WEST SUSSEX COUNTY COUNCIL CONSULTATION

TO:	Arun District Council FAO: Mr. S. Davis
FROM:	WSCC Highways - Public Rights of Way
DATE:	7 March 2022
LOCATION:	Land to the south of Ford Lane and east of North End Road Yapton BN18 0DS
SUBJECT:	Y/10/22/PL Erection of 15 No dwellings (including 4 No affordable units) with associated access, parking, landscaping, drainage and public open space (additional units to those approved under application Y/123/21/PL). This application may affect the setting of a listed building, affects the character & appearance of the Church Lane Conservation area, affects a Public Right of Way and is in CIL Zone 2 and is CIL Liable as new dwellings.
DATE OF SITE VISIT:	n/a
RELEVANT PUBLIC RIGHTS OF WAY NUMBER(S):	FP358
RECOMMENDATION:	More Information
S106 CONTRIBUTION TOTAL:	n/a

Drawing Title Sections through public right of way footpath 357

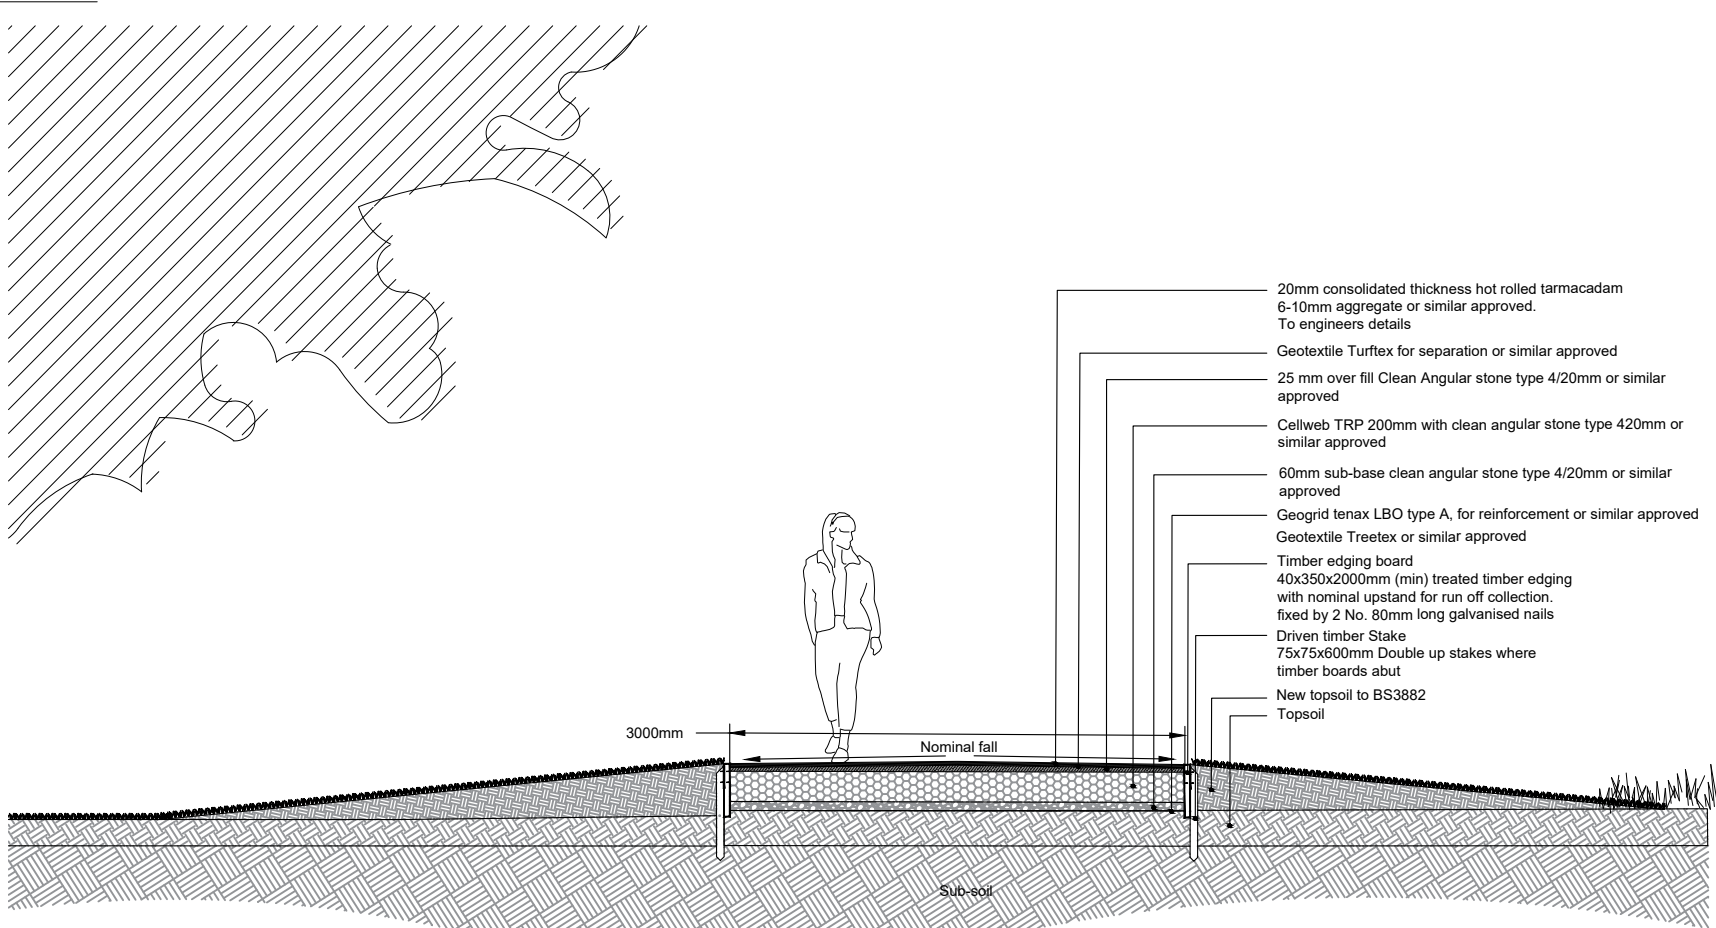
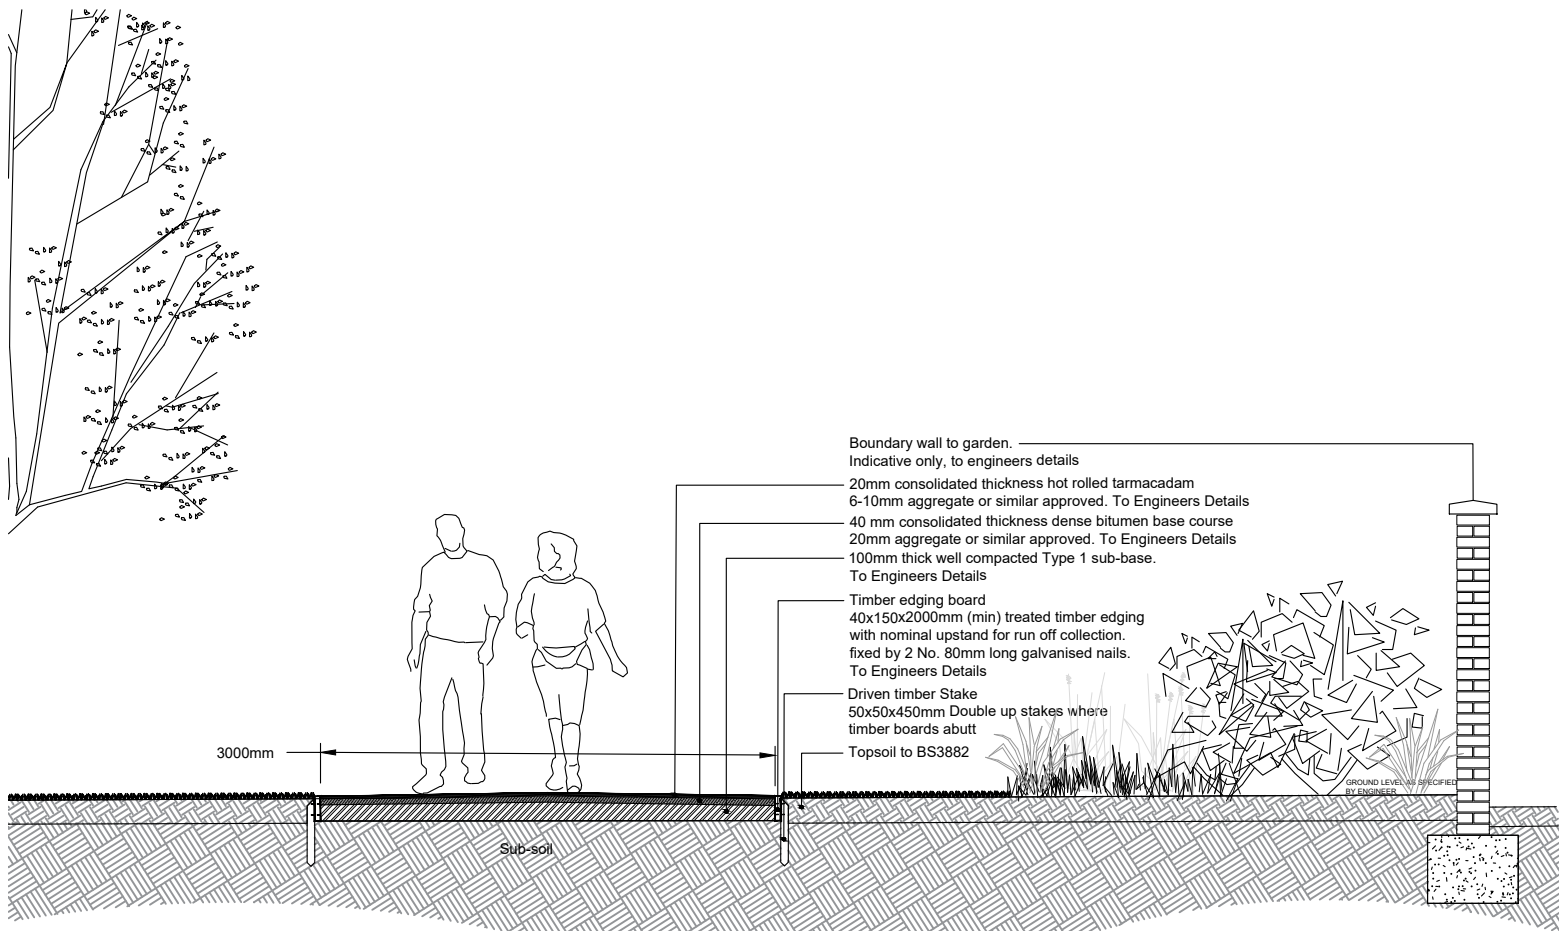
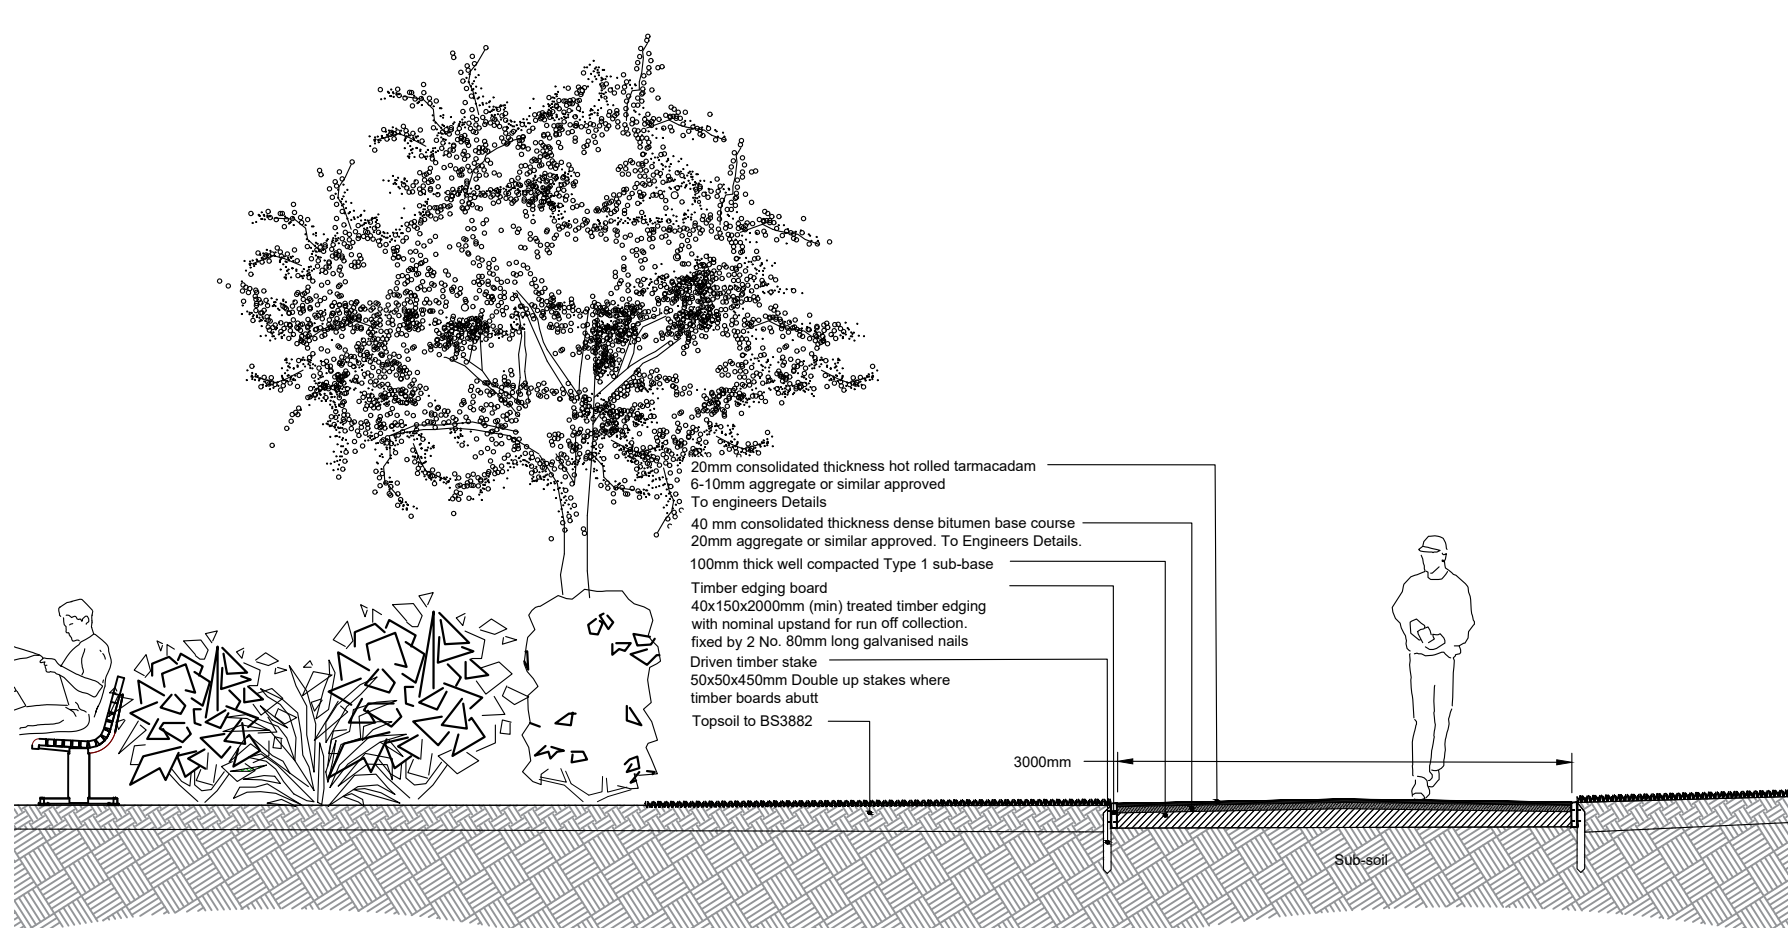
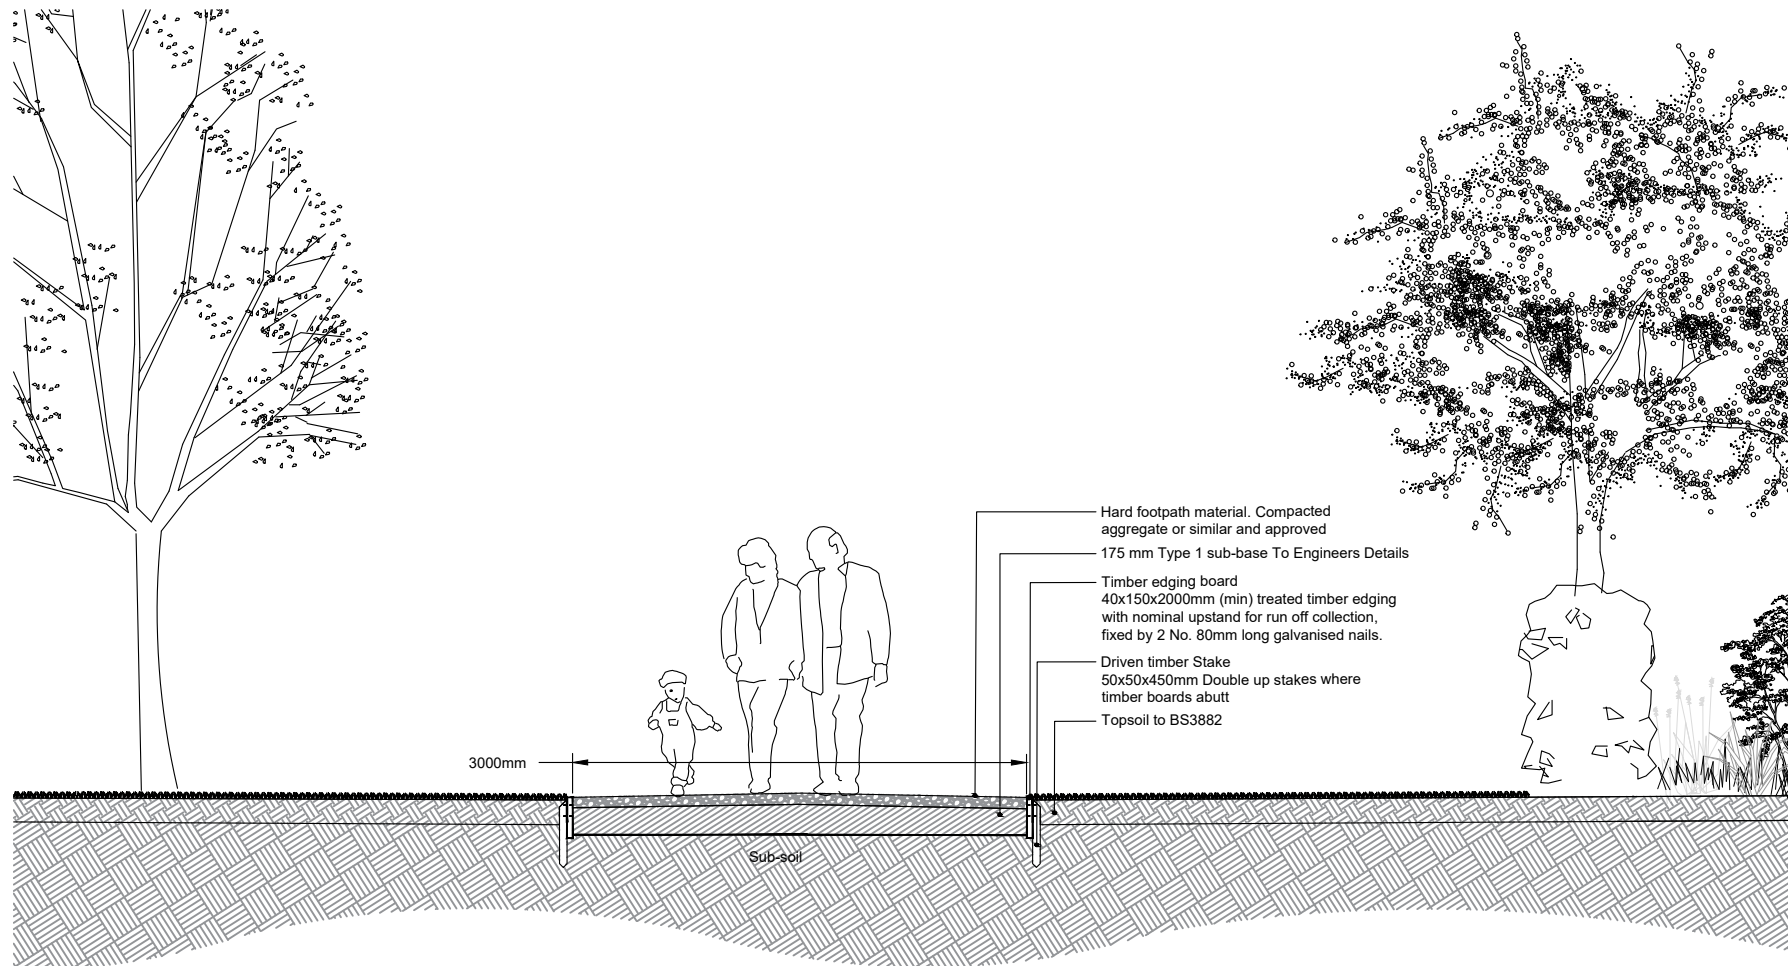
From the documents available this appears to refer to the resurfacing of FP358 along the eastern edge of the development site and FP357 (as discussed below). This was previously commented on in relation to Y/123/21/PL and looking at the proposed drawings including surface specification and widths I can confirm we have no objection to the surfacing and widths of FP358.

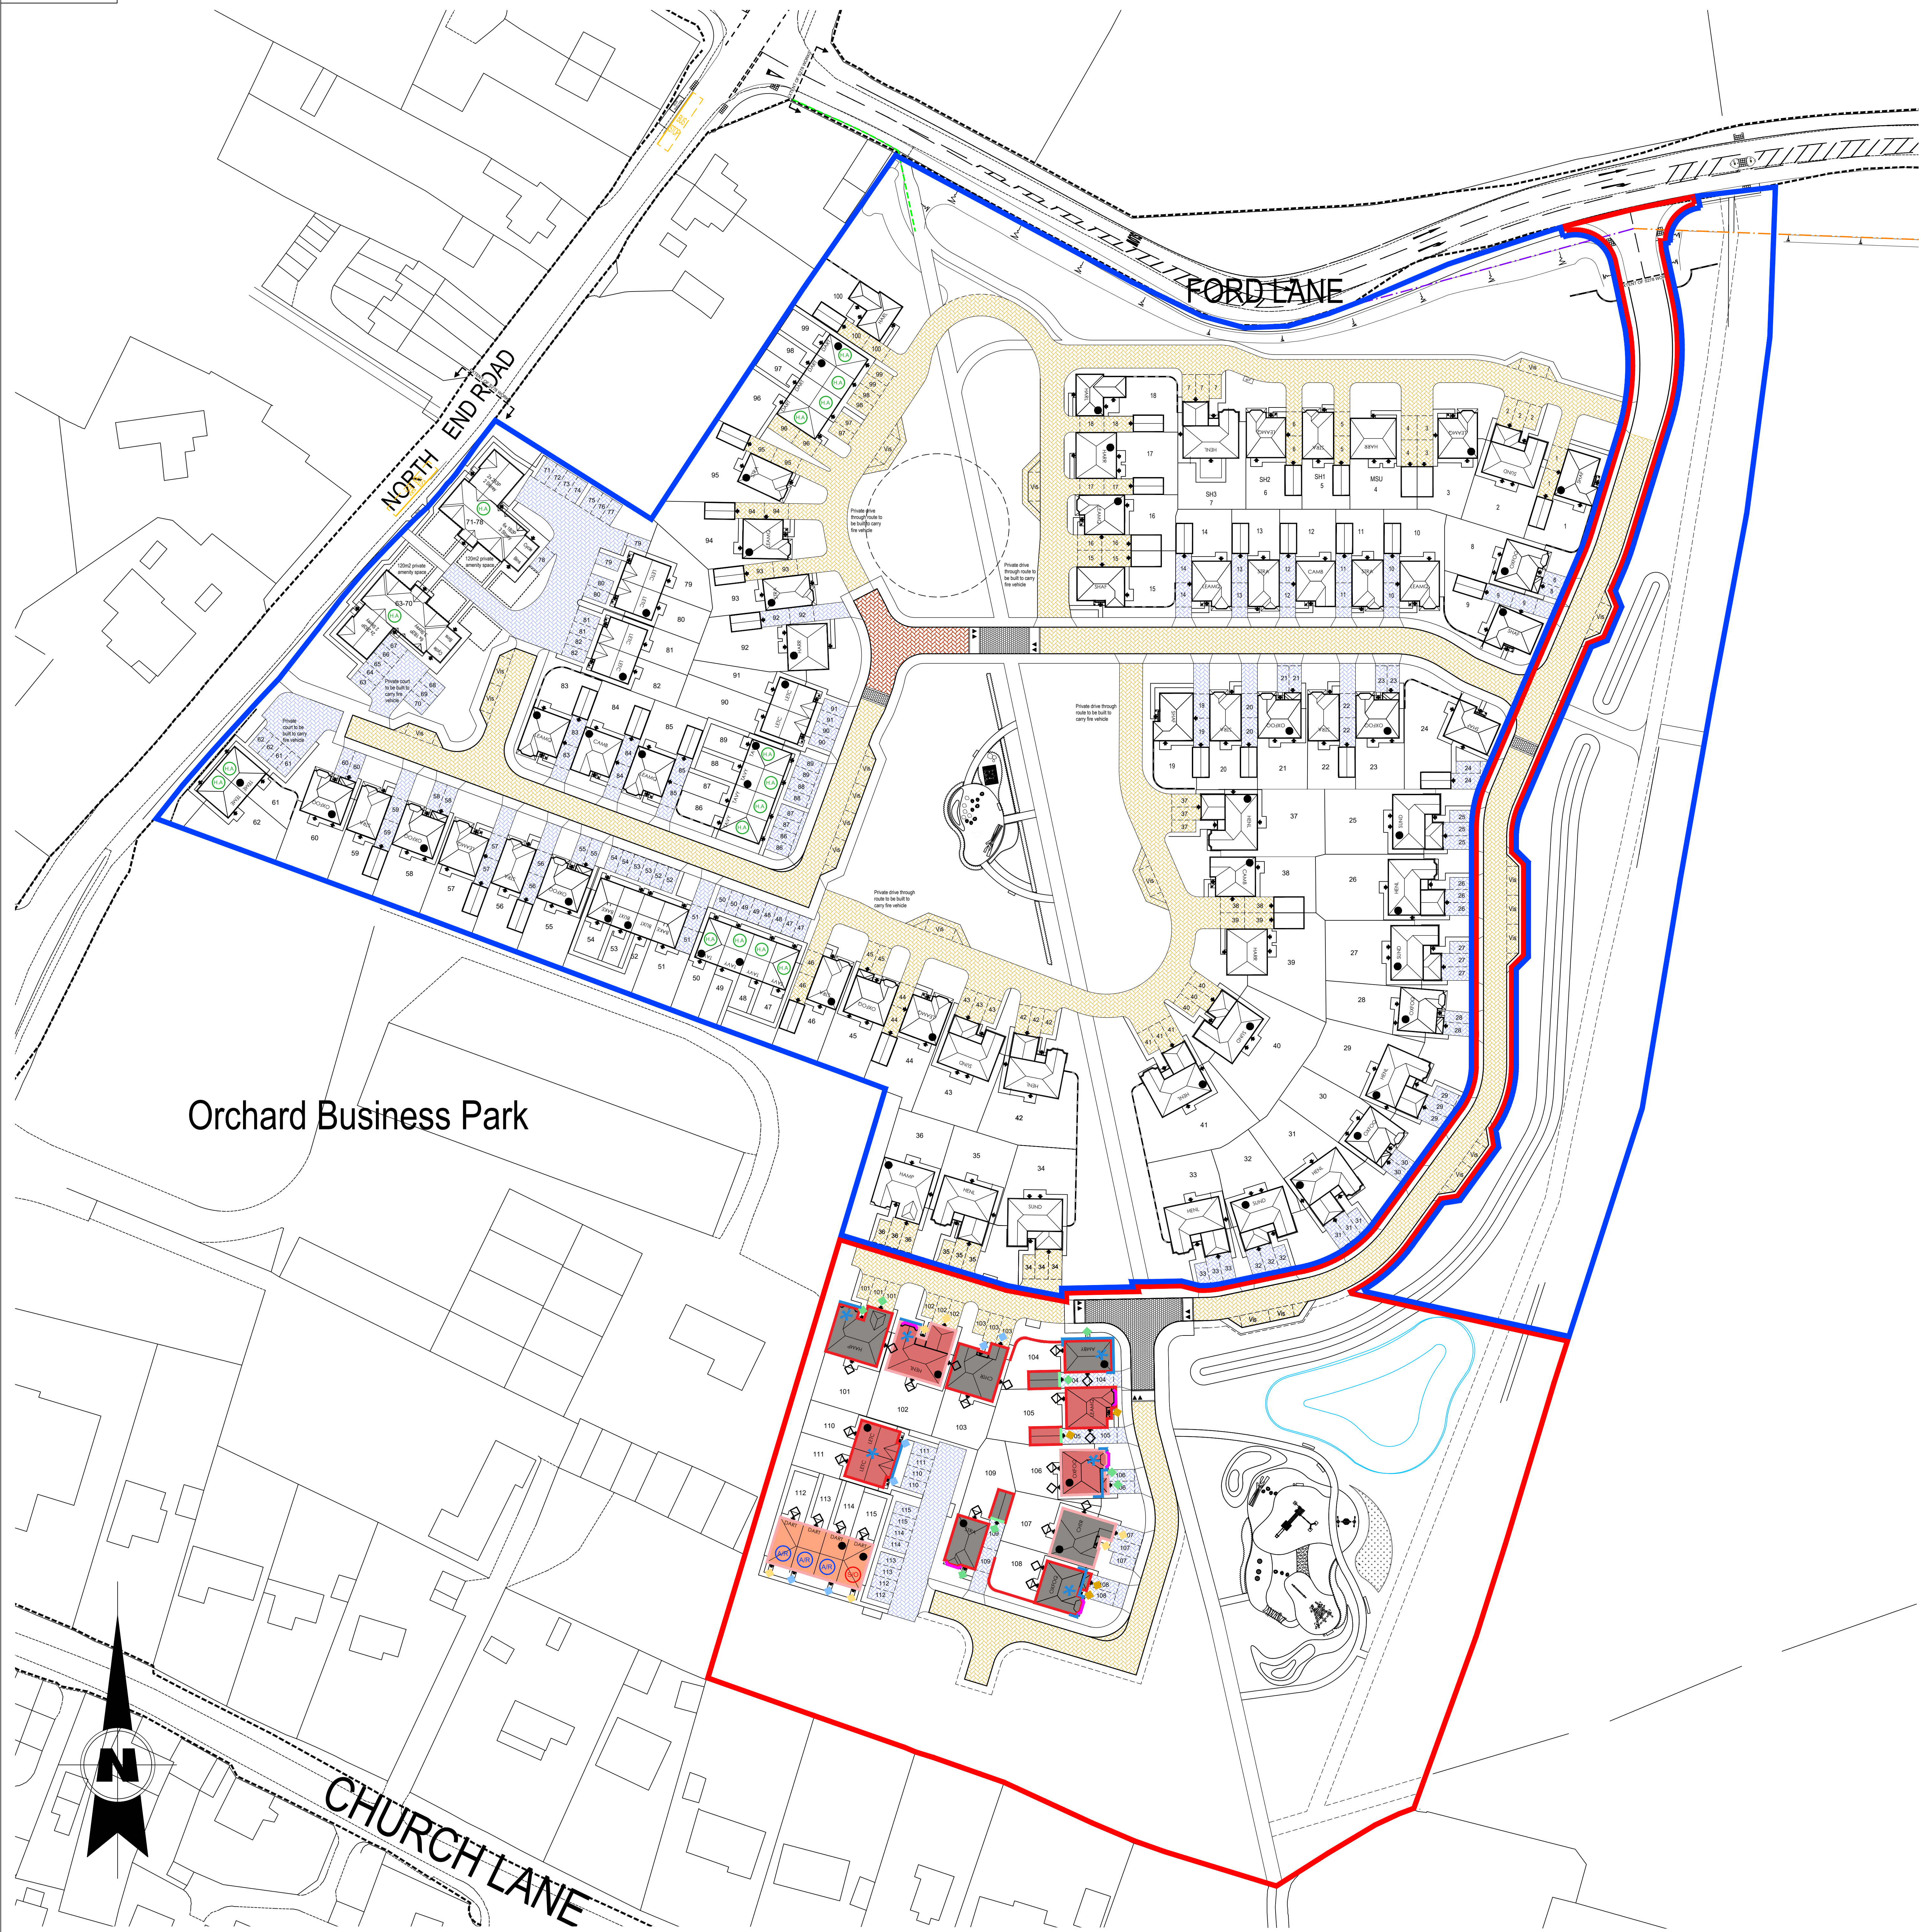
Another point I would like to raise is the proposed turning head featuring at the southern most point of the Redrow development previously comments on by PROW colleagues. It was requested that this be moved west so the line of FP could be as it currently exists. The layout featuring in this application appears to make it challenging for users to follow the legal line of the footpath as any crossing facilities will need to be a suitable distance away from the turning head so tactiles etc can be accommodated. I was under the impression this had been agreed but the turning head proposed here does not reflect this. The importance of this may be more important in the future as we would like to see bridleway rights along this route in the future so a safe crossing layout should be available for lawful path users to follow. Considering this the layout illustrated in this application does not sufficiently accommodate existing lawful users, let alone potential future use, and we would like to see this reviewed in line with what was previously agreed to our knowledge in relation to the previous application for the land immediately north. Therefor we would like to see some additional information on how this turning

head may be changed to accommodate the legal line of FP357 and if not where the FP could be diverted to to avoid users having to cross at the turning head.
